Submissions Report

Punchbowl, Affordable Housing, State Significant Development

150 The Boulevard and 34 Dudley Street, Punchbowl

SSD-83256463

Drawing Title Sun Eye Diagrams

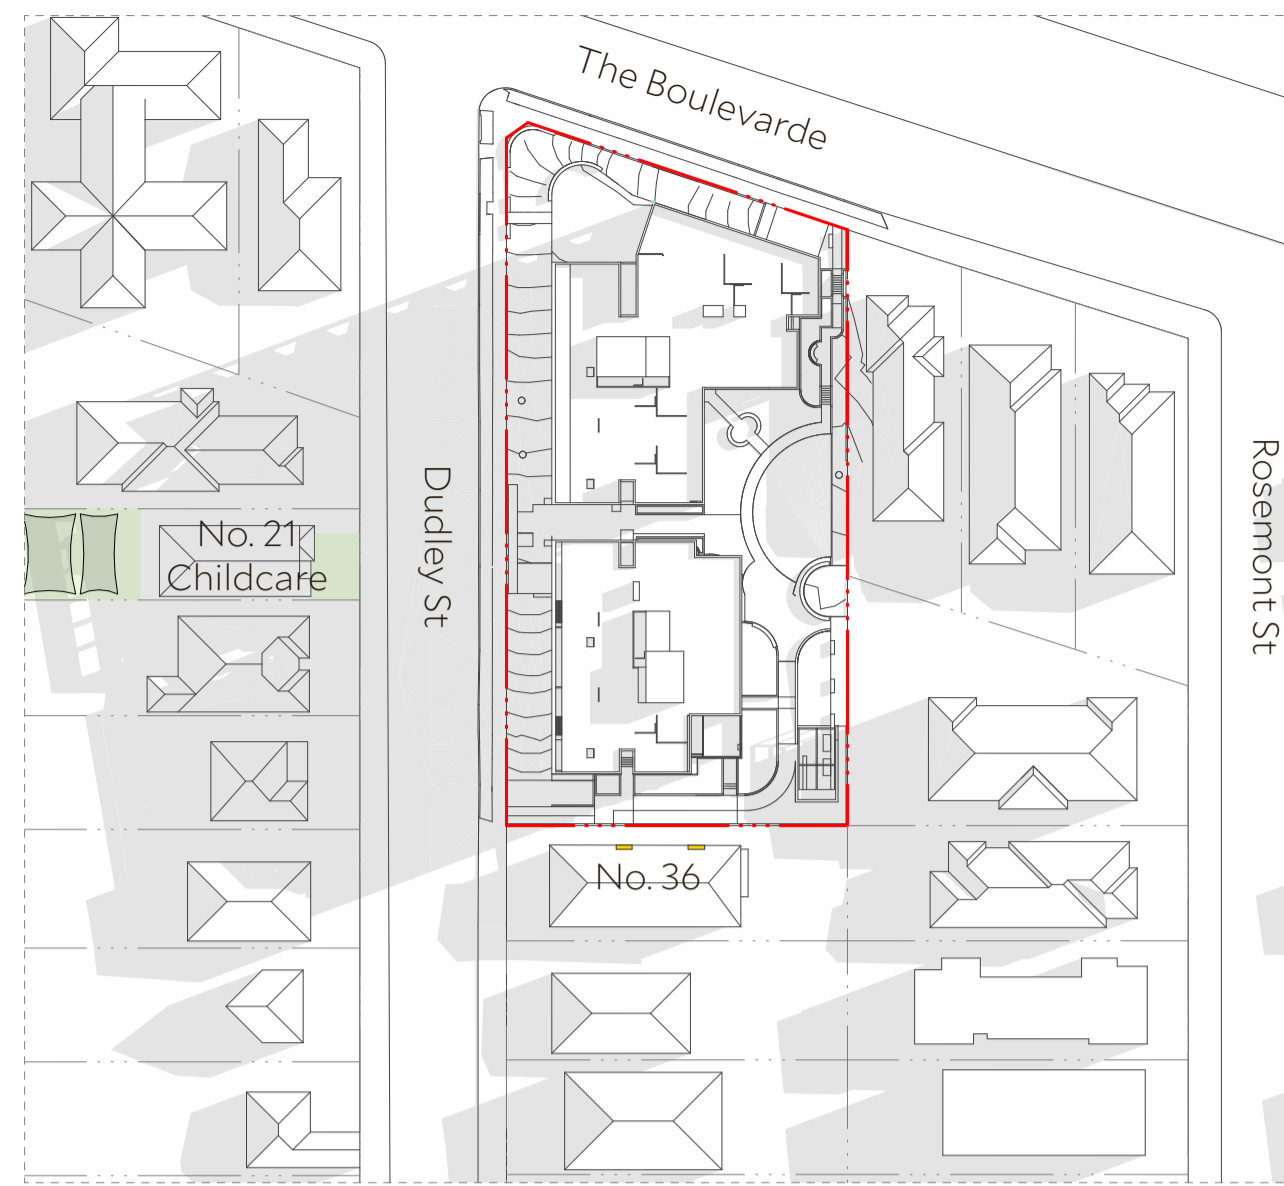
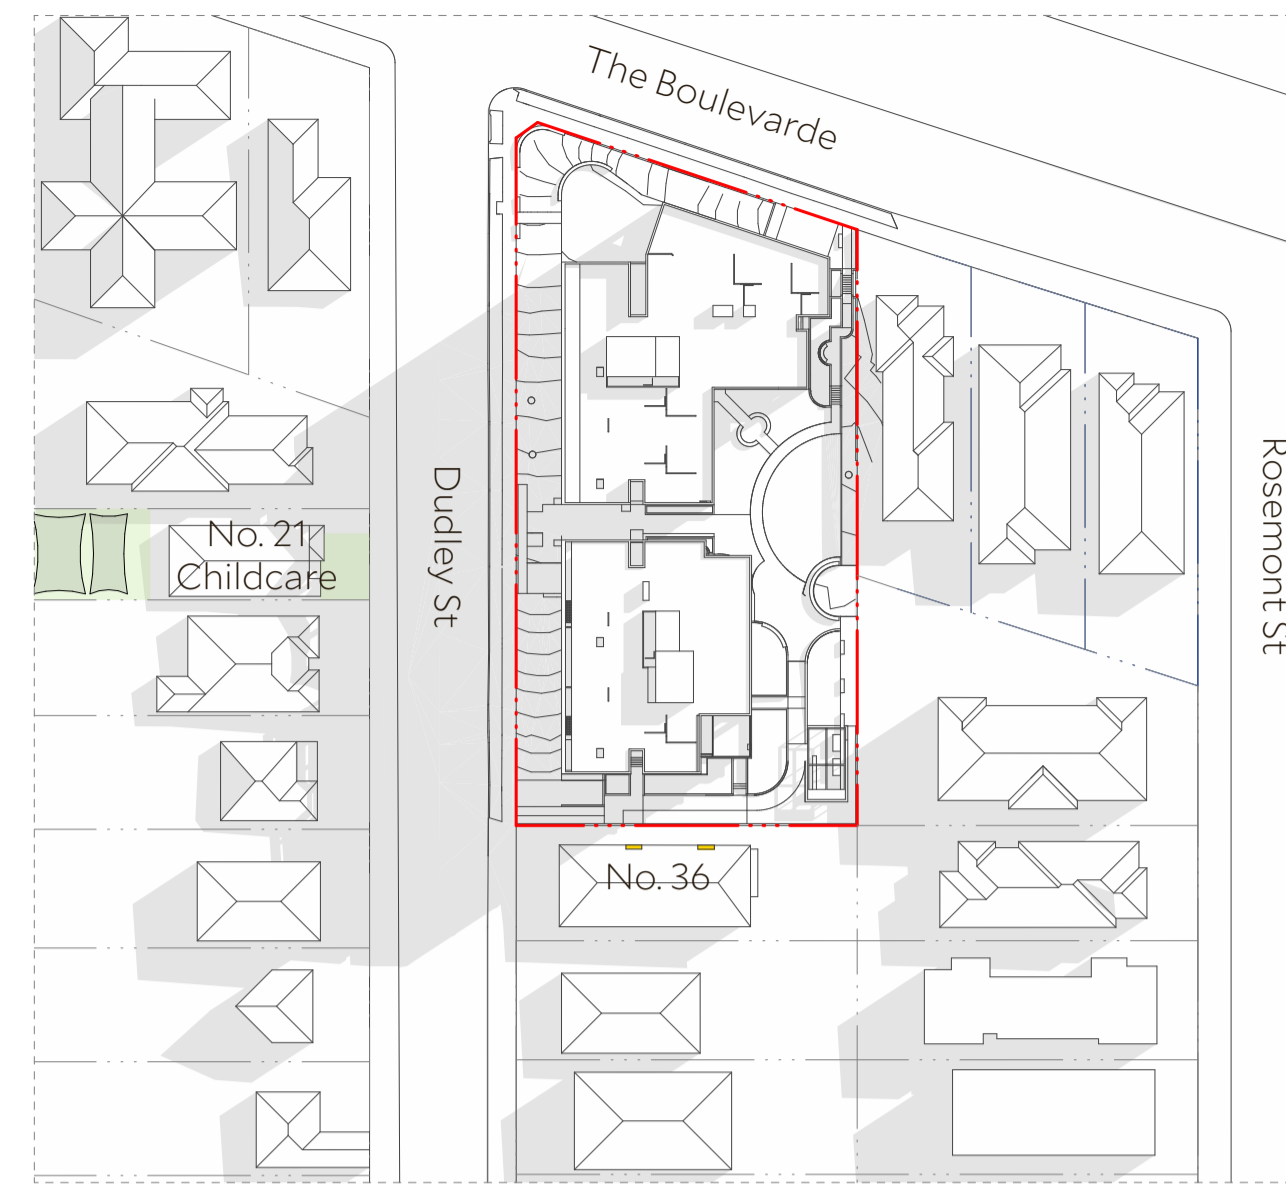
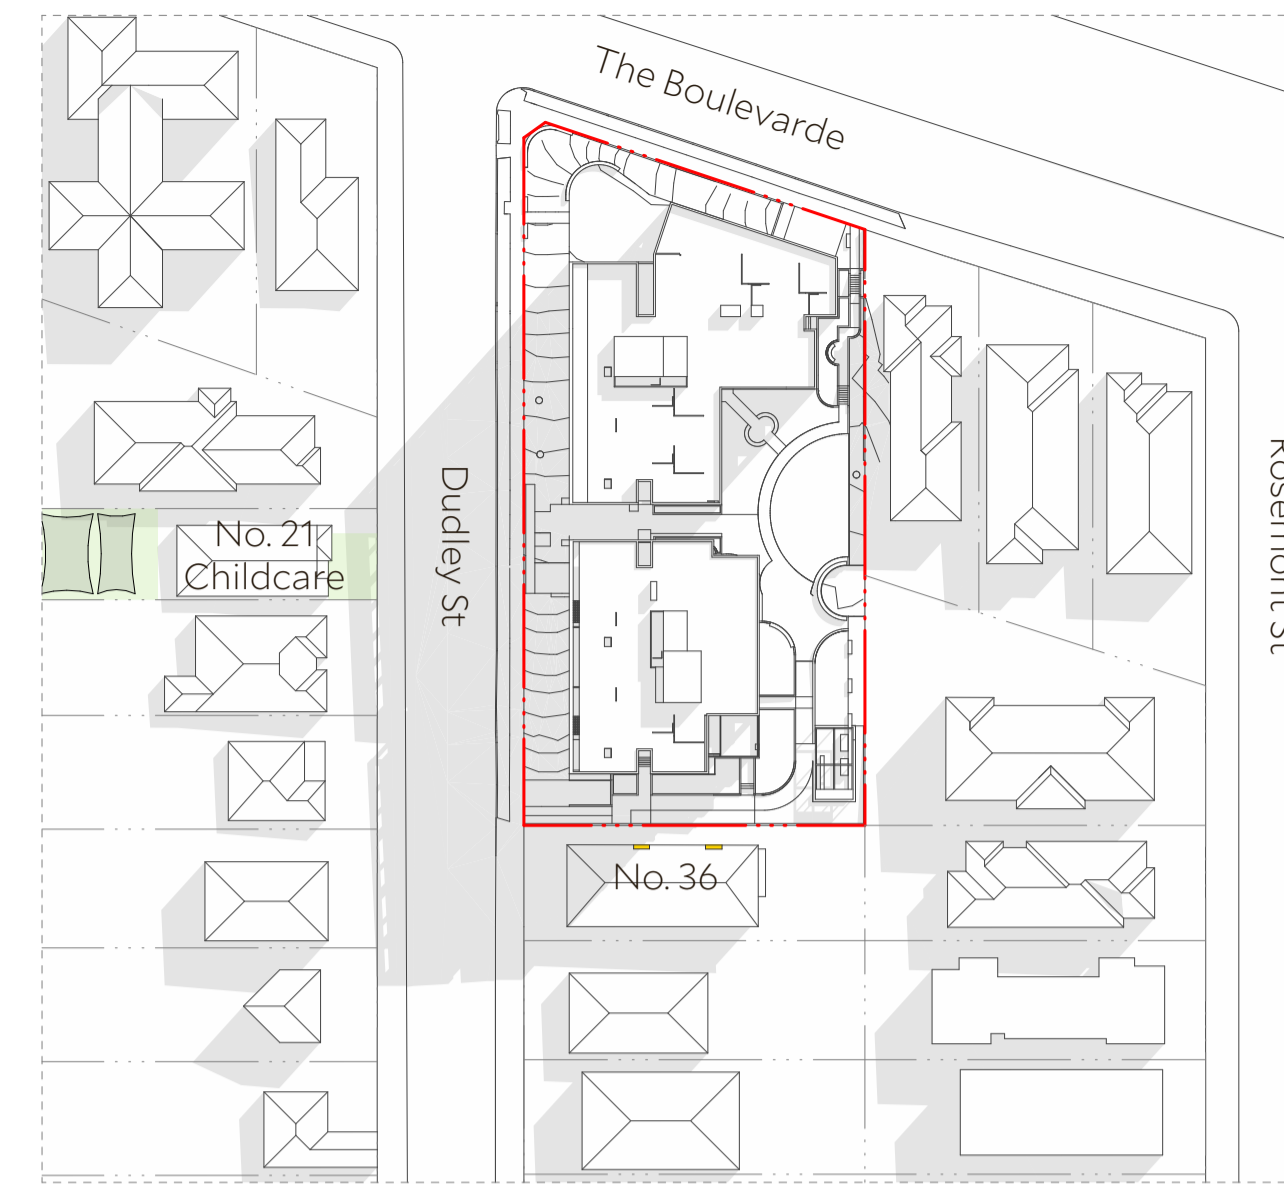
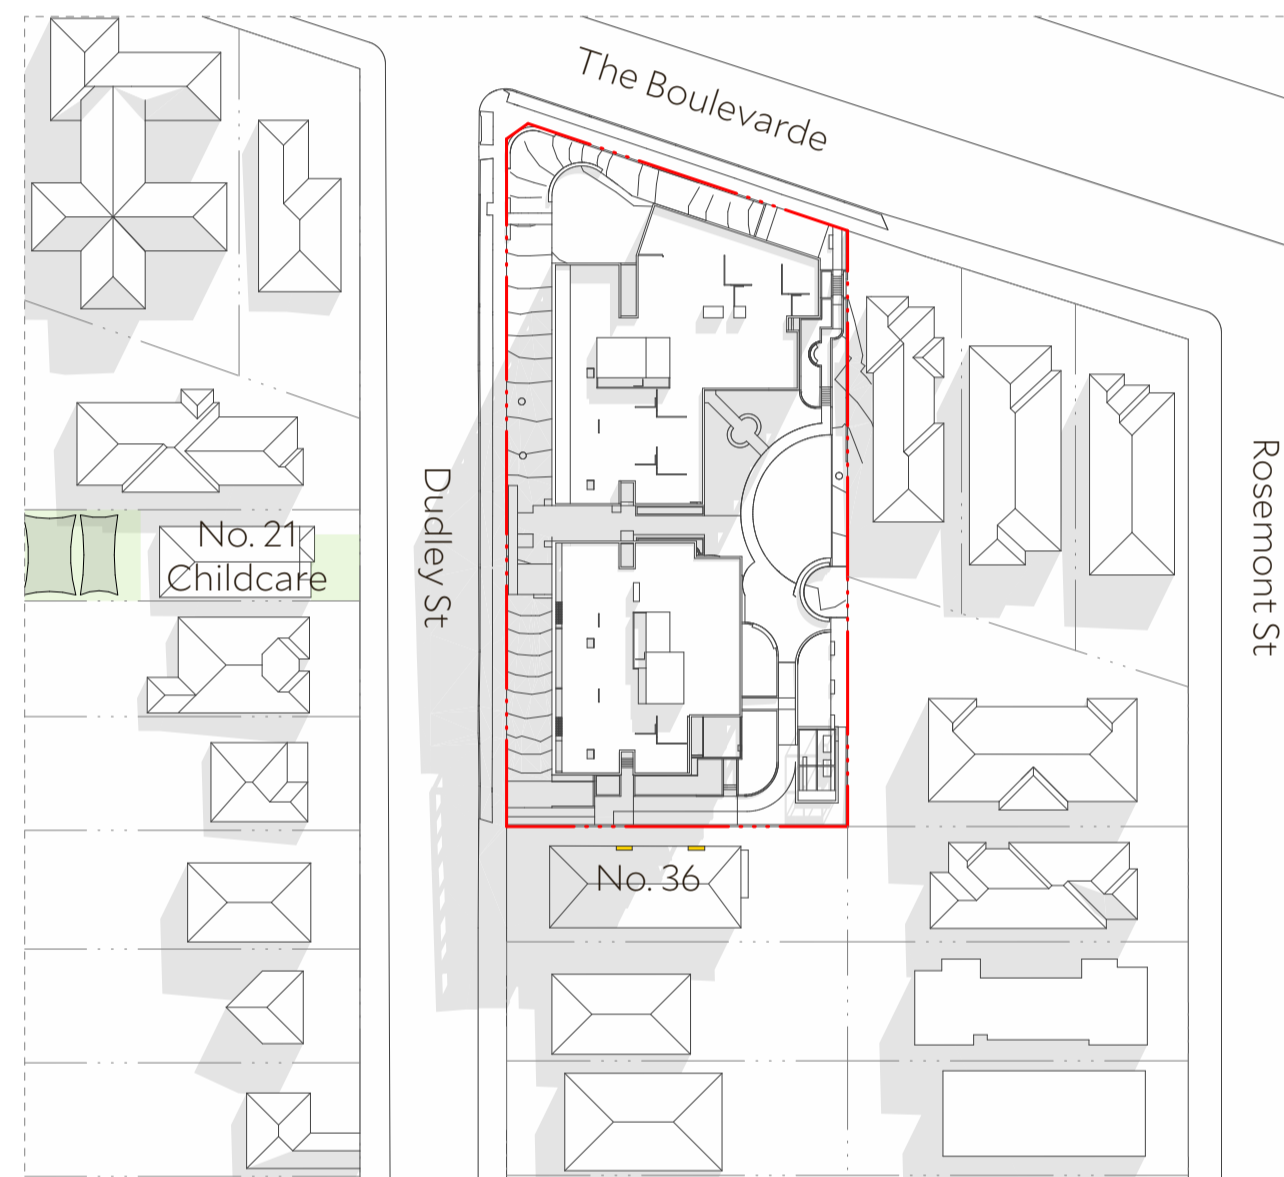
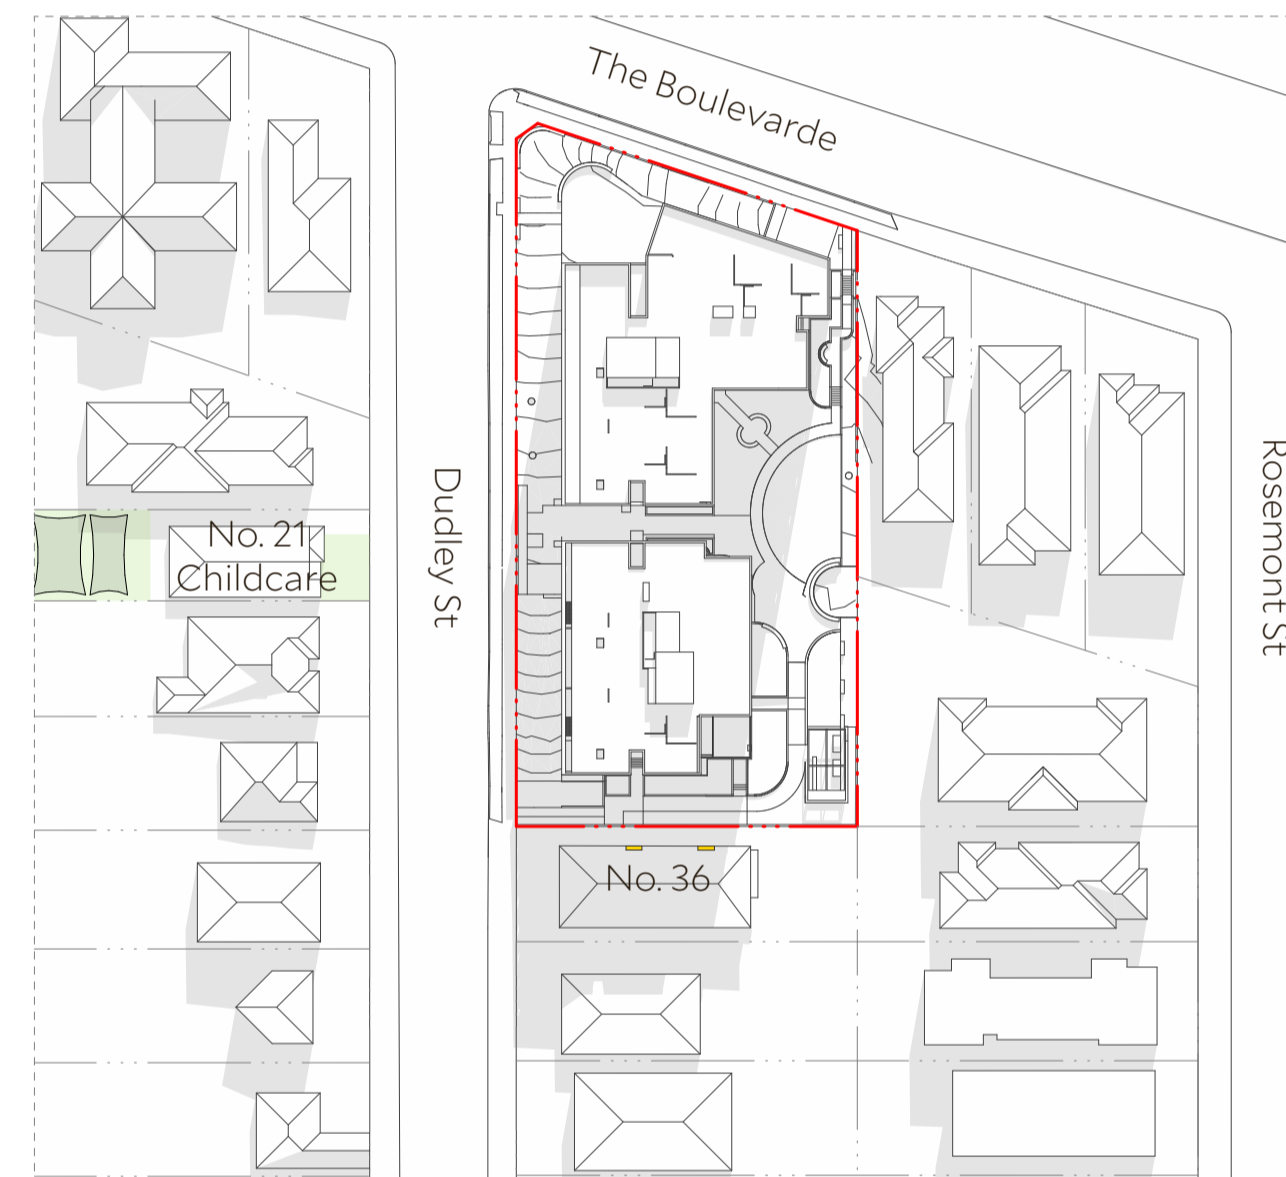
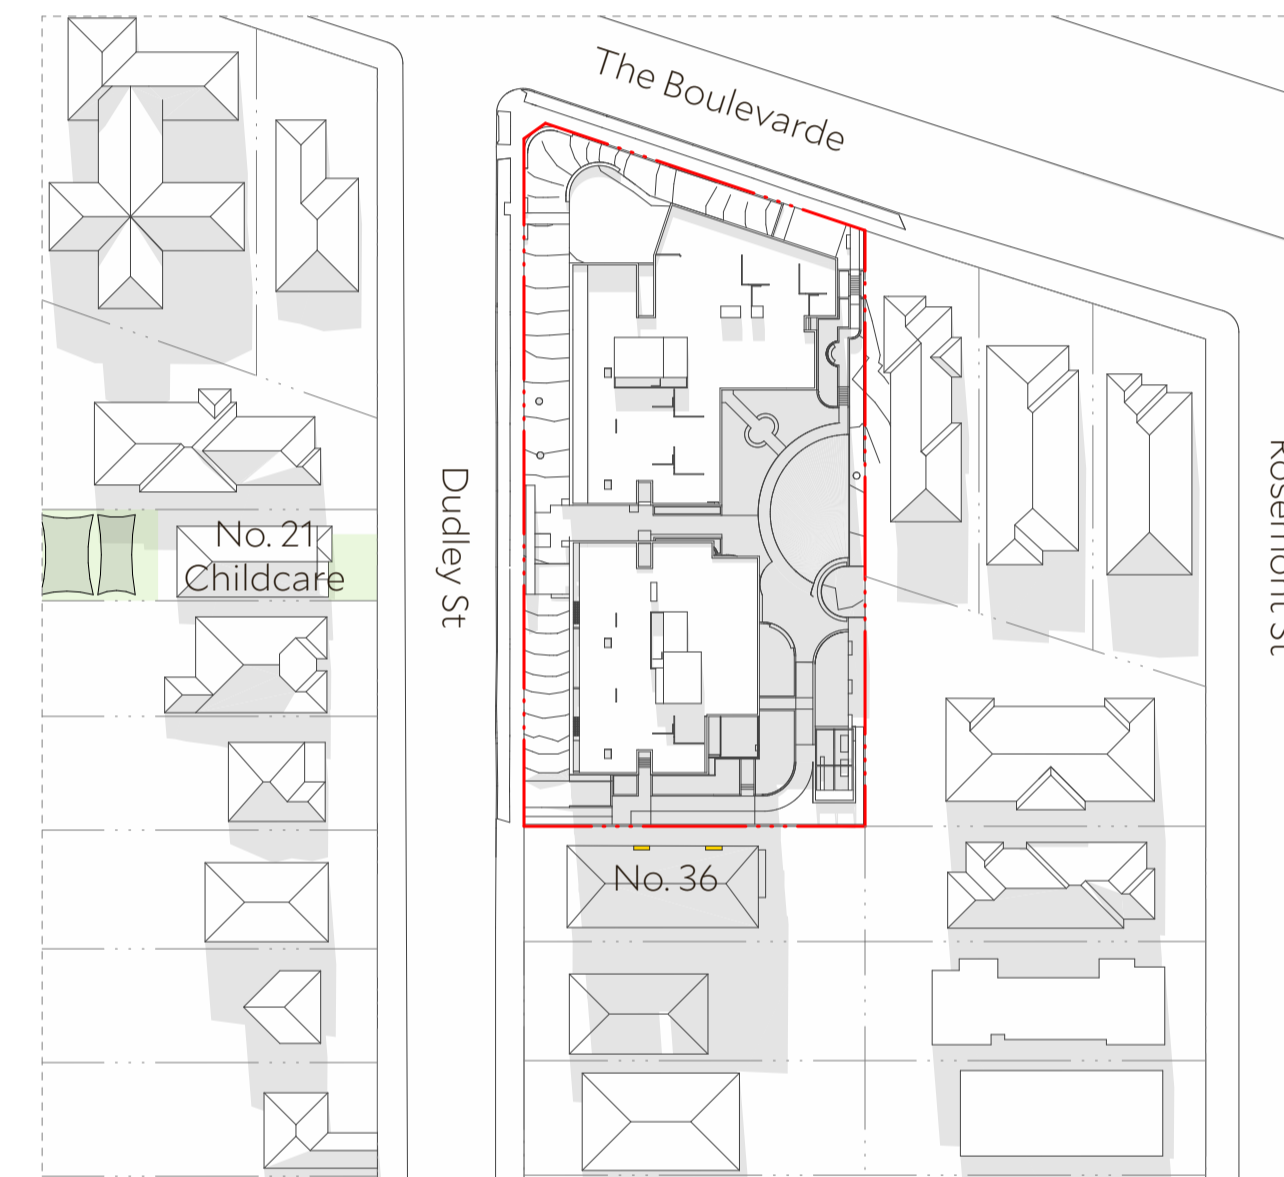
3.2	As raised by Council, further investigation is required to identify all living room windows at No. 36 Dudley Street to verify overshadowing impacts.	All living room windows at 36 Dudley Street have been identified and assessed in the updated Sun Eye View diagrams in the updated Architectural Plans at Appendix B. The updated Sun Eye Diagrams confirm that the proposal will not result in any overshadowing to the additional two living room windows at 36 Dudley Street between 9am and 12pm, mid-winter.

5.5	To the south of the site is a two storey Residential Flat Building (RFB) at 36 Dudley Street. The SSDA Design Report advises this RFB as two northern elevation living room windows (one on each level for Units 1 and 4) which must each receive at least two hours sunlight between 9am and 3pm in midwinter. However, Council's records (file 253/36B) show this RFB as having two additional living room windows (relating to units 3 and 6) and which are the two easternmost windows on the northern elevation. <u>Recommendation:</u> Amended plans be provided that accurately show the living rooms on the RFB at 36 Dudley Street and them receiving adequate solar access in midwinter.	All living room windows at 36 Dudley Street have been identified and assessed in the updated Sun Eye View diagrams in the updated Architectural Plans at Appendix B. The updated Sun Eye Diagrams confirm that the proposal will not result in any overshadowing to the additional two living room windows at 36 Dudley Street between 9am and 12pm, mid-winter. The proposal maintains a minimum of 2hrs solar access to all identified living room windows at 36 Dudley Street, between 9am and 3pm, mid-winter.

No.	Issue raised	Response
		The proposal maintains a minimum of 2hrs solar access to all identified living room windows at 36 Dudley Street, between 9am and 3pm, mid-winter.
